Planning Consultation Memo

Date	Planning Officer	Environmental Health Officer
23/11/16	June Pagdin	Karl Riahi
Planning Application Number	Worksheet Number	
6/2016/1866/FULL	WK/81364

Address: 6A Parkhouse Court, Hatfield, AL10 9RQ

Application Details: Installation of two refrigerator condensing units

CLIENT:	MS WING SZE CHUNG	<b>HAPPY ARCHITECTURAL SERVICES</b> ARCHITECTURE DESIGN, BUILDING CONTROL		<b>HAS</b>
PROJECT:	648 NAGOYA ORIENTAL STORE			
DRWG NAME:	PROPOSED ELEVATION	TEL: 07720323060 e-mail: hapyeung@yahoo.com		
DRWG NO:	002-03	SCALE: 1:50 @ A3	OCT 16

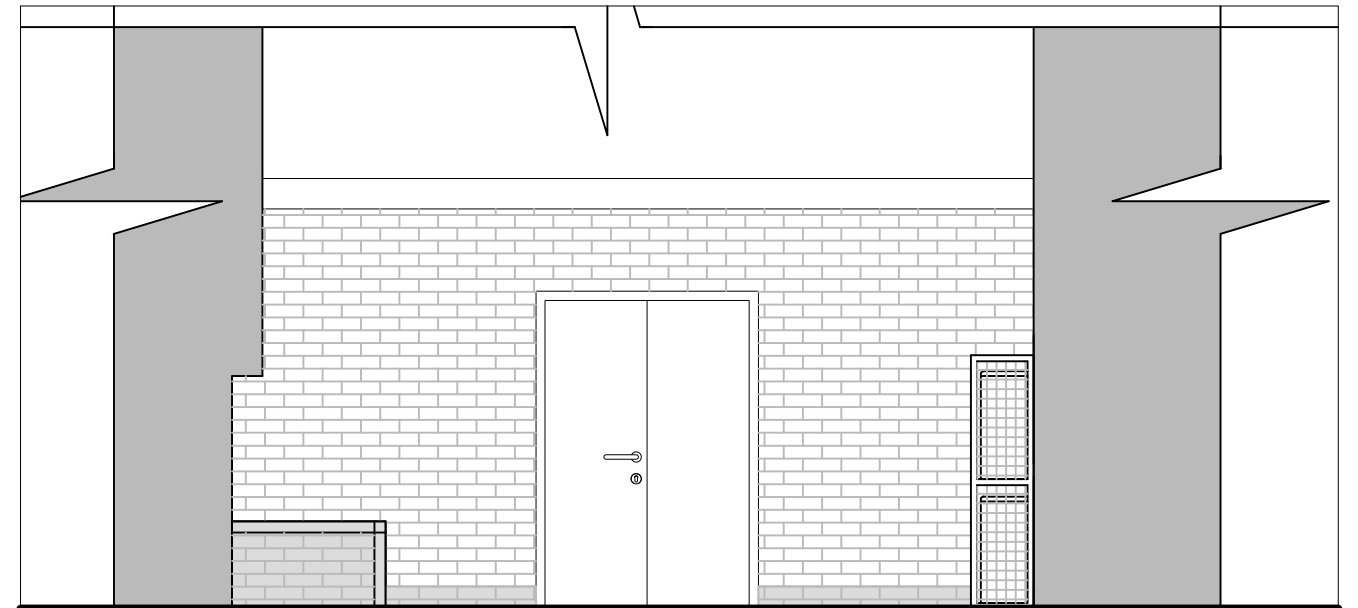
Noise levels for the external condensing units has been given as 34dB at 10m. When taking into account distance attenuation, existing fan units in the area and shielding effects from the building and balconies, it is unlikely that these units will cause an issue in terms of noise.
